WSCC CONSULTATION RESPONSE:
County Planning – Minerals & Waste Planning Authority

TO:	Arun District Council Case Officer: Raymond Cole						
DATE:	2 April 2020						
LOCATION:	Ford Airfield Market, Ford						
SUBJECT:	F/5/20/PL - Reconfiguration of Ford Market, including revised market access, hardstanding for replacement vehicular parking and associated infrastructure, landscape, ancillary and site preparation works.						
RECOMMENDATION:

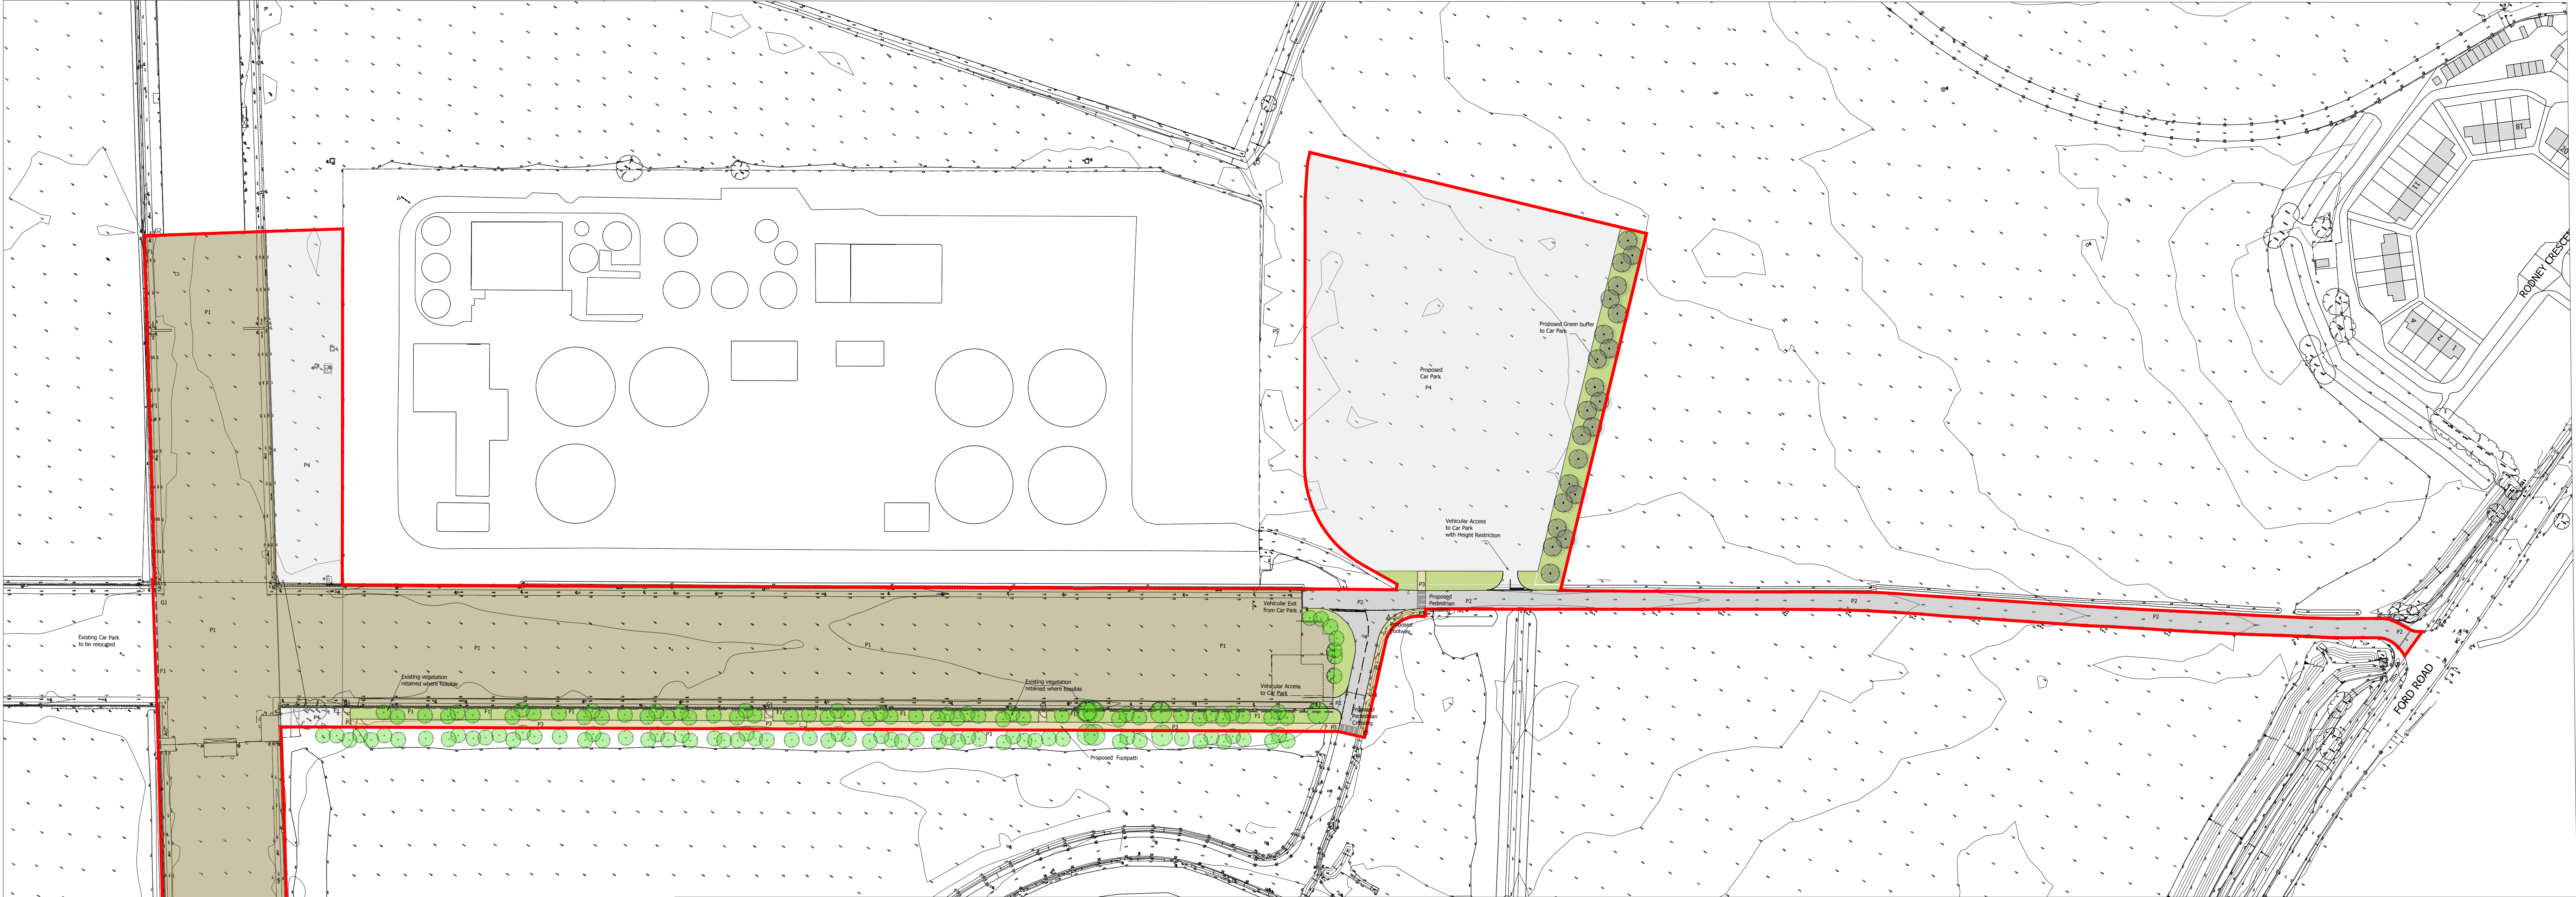
It is of note the submitted plans do not detail the existing access (and associated landscaping/drainage) to the CTP site, which is both implemented and in use. Submitted assessments do not take into account relevant EIA assessments provided in support of developments at the CTP site, or neighbouring waste sites, or controls attached to permissions thereto (e.g. routing, hours and volumes of HGV movements).
